Case Number: 170412

**LETTER of CONDITIONS
For
BUILDING OVER/ADJACENT TO A SYDNEY WATER ASSET**

Applicant: TANNER KIBBLE DENTON ARCHITECTS
Your reference: 2017-0476
Property location: 7-11 Park Road, Alexandria
Development Description: The proposal is to redevelop the existing primary school at 7-11 Park Road, Alexandria and provide a single campus for Kindergarten to Year 12 students, involving the addition of new classrooms and the capacity to house 2,200 students on the site, along with providing sporting facilities and provision of 10m² of open play space. The current school has buildings over the stormwater culvert. The new design has considered the impact on the stormwater channel and all envisage the need to cross the easement as a critical component to deliver an integrated school development. An access/evacuation bridge is also proposed over the channel. Detailed reports have been completed on flood risk, stormwater management, access/civil works and CCTV of the asset.

Figure 3: Location of Sydney Water Easement

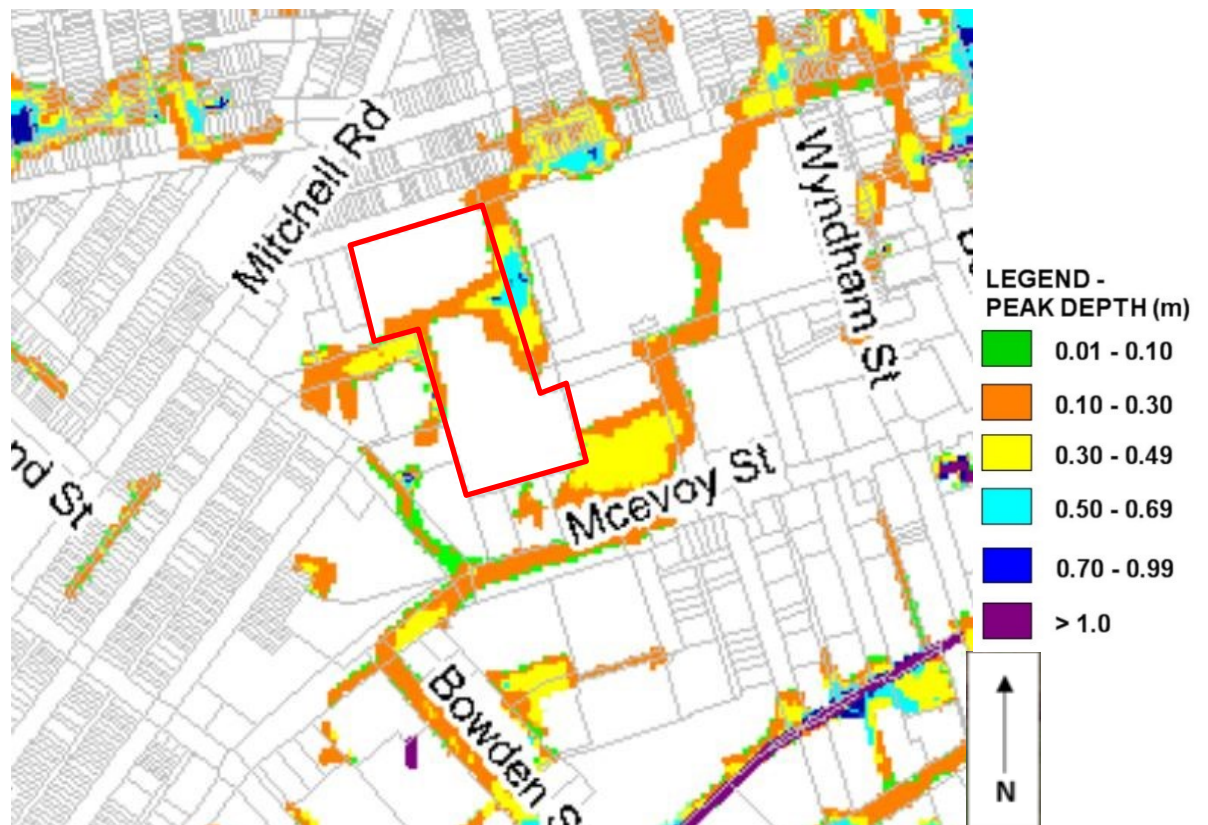
Open stormwater channel to be enclosed

Enclosed section to be extended 1.0 past both ends of any structure

No part of the building to be within 1.0 from the outside of the new storm water
